From: Daniel Carpenter <Daniel.Carpenter@arun.gov.uk>
Sent: 19 February 2026 10:10
To: Planning.Responses <Planning.Responses@arun.gov.uk>
Subject: Planning consultation on: BR/18/26/PL

Please see Private Sector Housing comments below. These comments are in relation to Houses in Multiple Occupation (HMOs) and have regard to the Housing Act 2004, The Licensing and Management of Houses in Multiple Occupation and Other Houses (Miscellaneous Provisions) (England) Regulations 2006, The Licensing of Houses in Multiple Occupation (Mandatory Conditions of Licences) (England) Regulations 2018, Arun District Council's HMO Standards, Housing Health and Safety Rating System (England) Regulations 2005 and LACoRS national fire safety guidance

1 0 - Proposed Ground Floor.
1 : 50

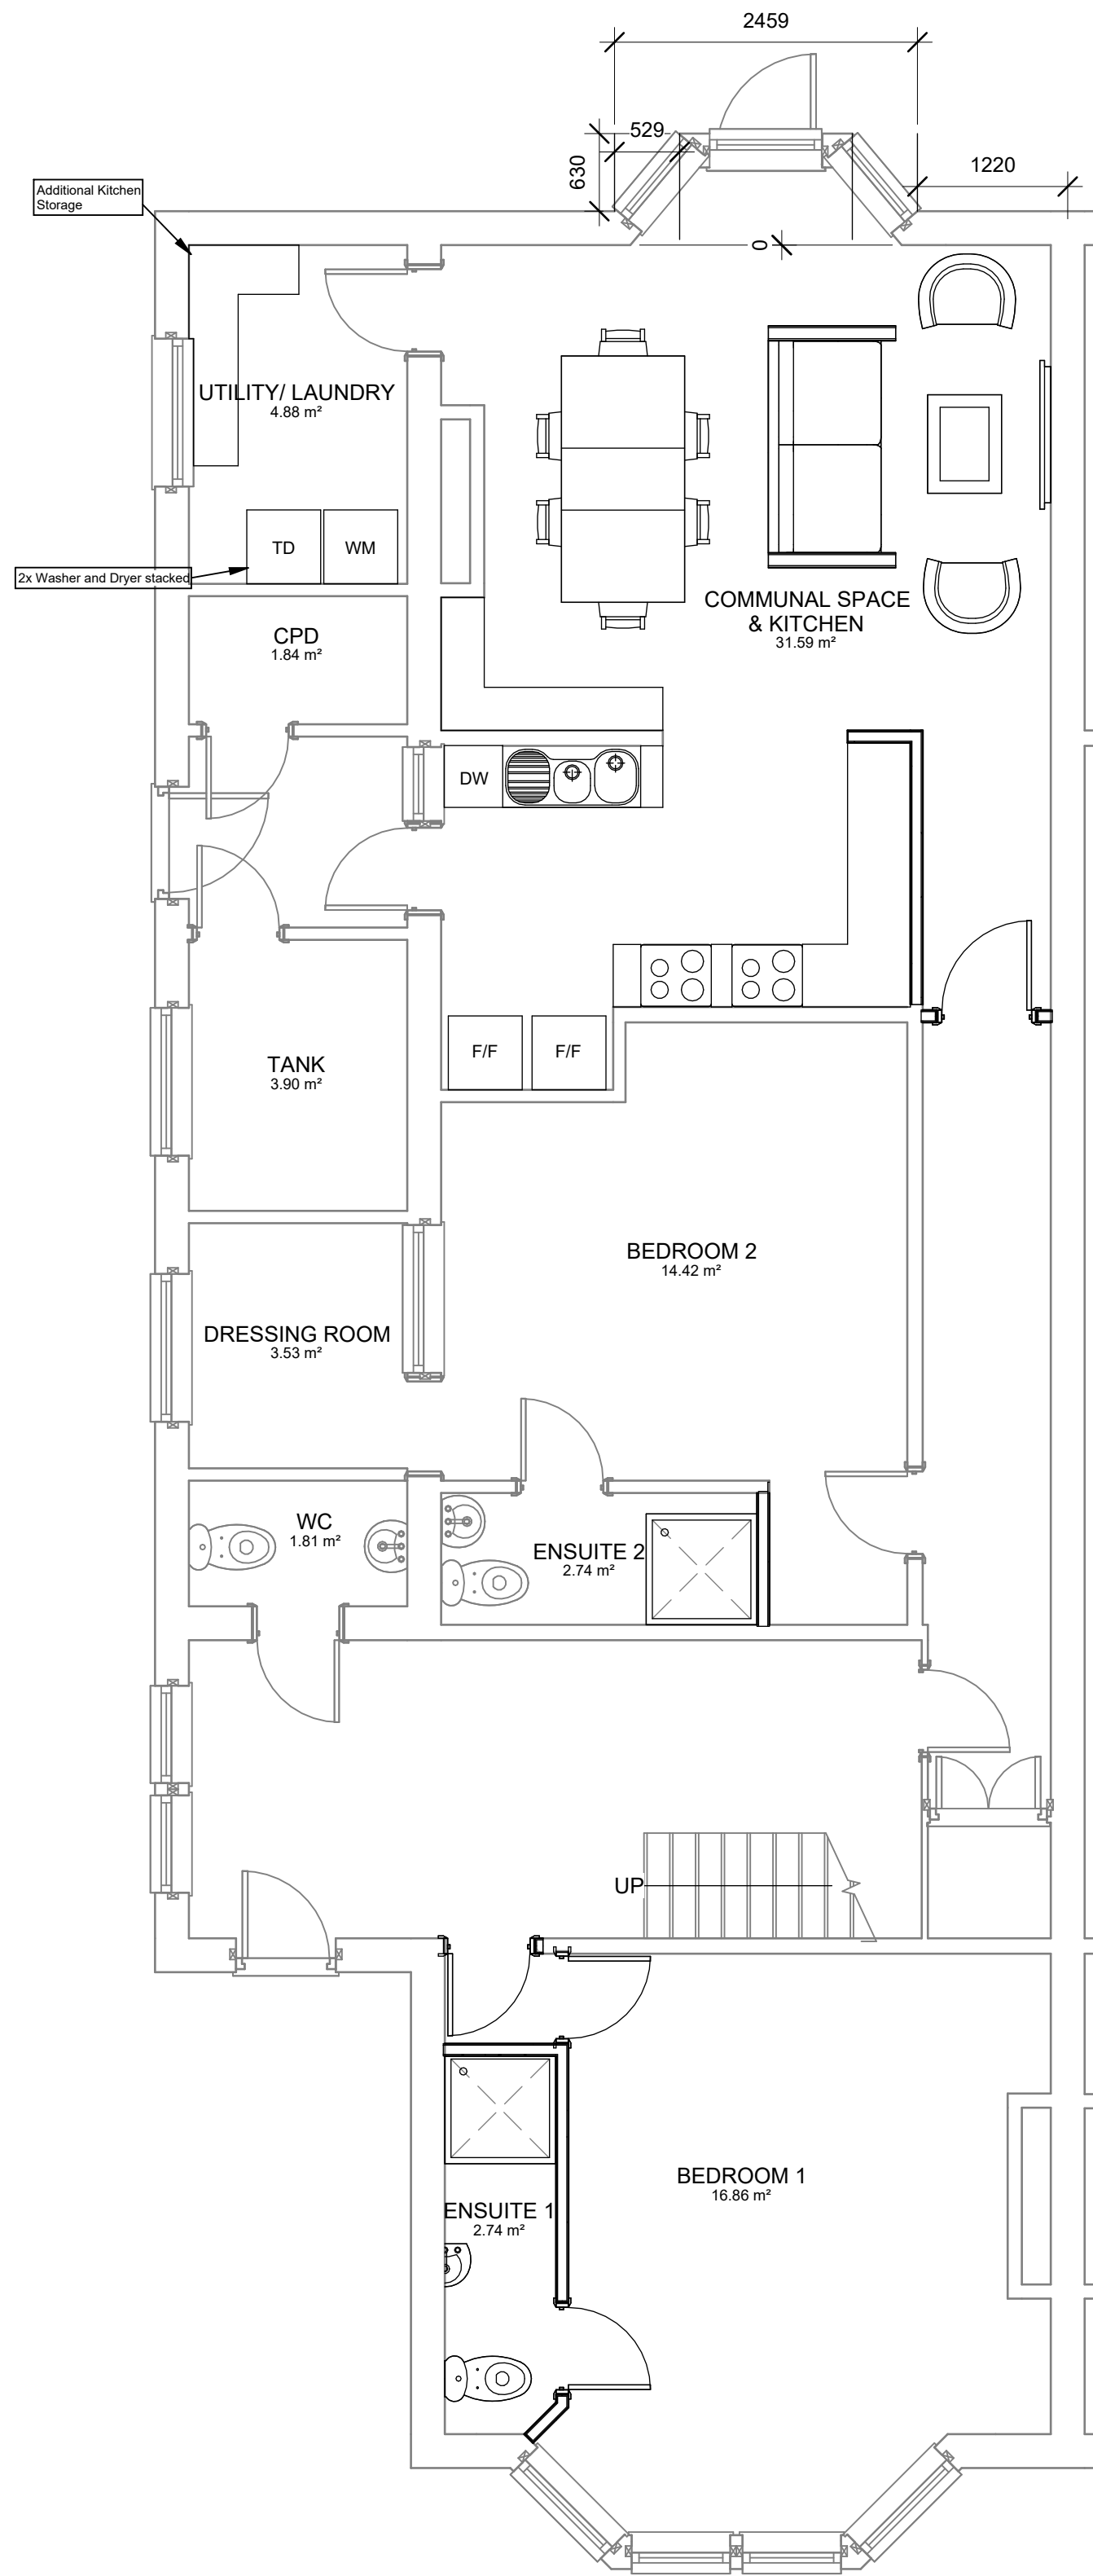
- The proposed plan identifies the kitchen diner size is more than adequate for the total number of occupants allowed, the minimum being 23.5m² for 13 occupants.

- 13 occupants require the following kitchen facility provision –
 - 3 x sink and drainers OR 1 x dishwasher and 1 x sink and drainer

- 3 x cooking appliances (ovens with 4 x ring hob/burners and grill) OR 1 x combination type microwave oven AND 1 x cooking appliance (oven with 4 x ring hob/burners and grill)
- 7 x double sockets above worktop height
- 500mm minimum of worktop space to be provided per occupier, totalling 6.5m of usable worktop space.

2 Proposed First Floor.
1 : 50

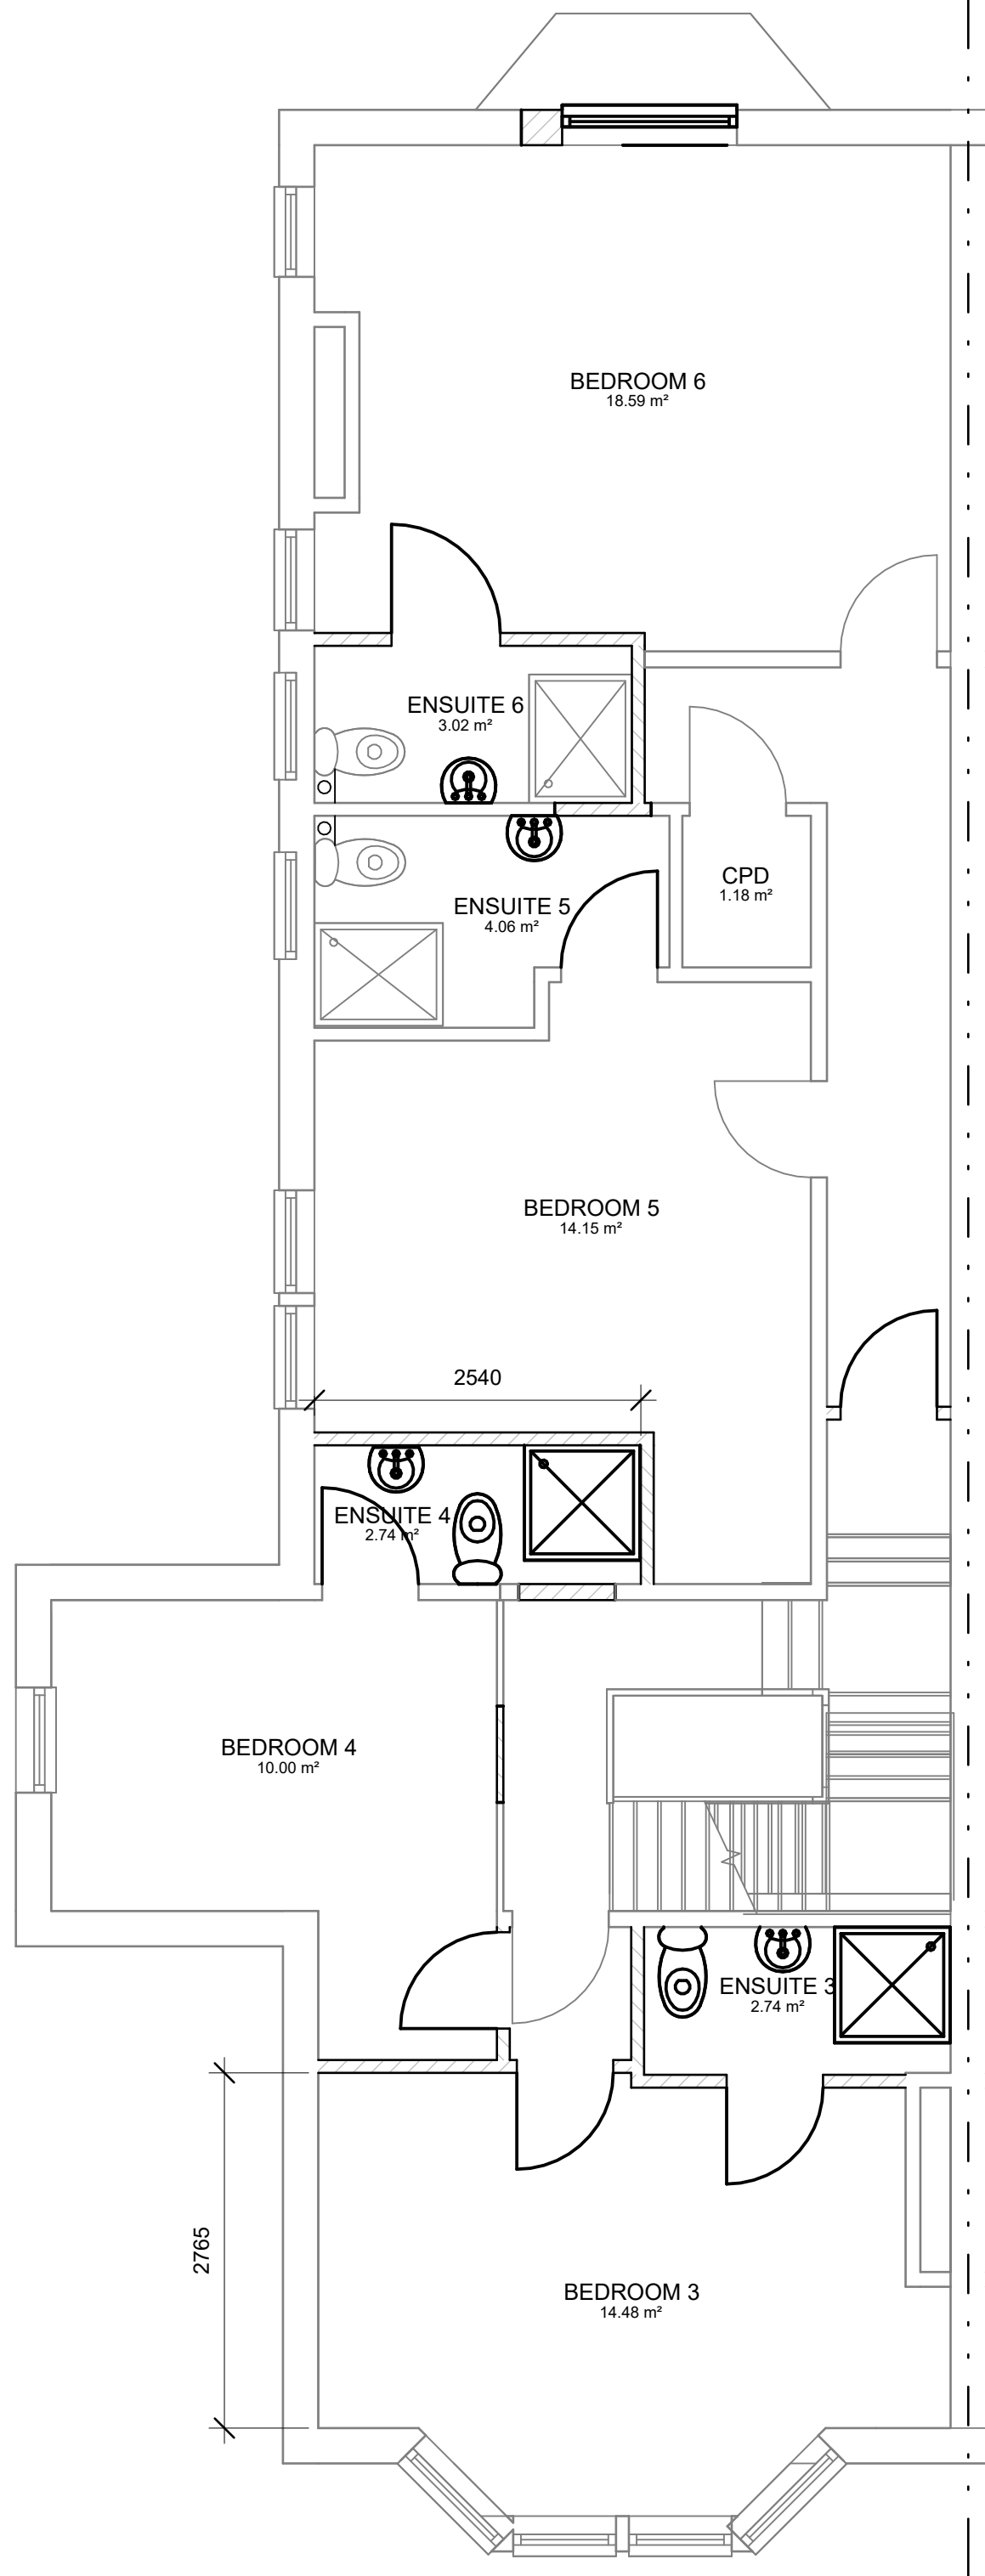
- The proposed plan identifies all bedrooms are large enough for double occupancy excluding Bedroom 4 (first floor) which falls just short of the minimum size at 10.00m² where the minimum size is 10.20m². This would allow for a total of 13 occupants.
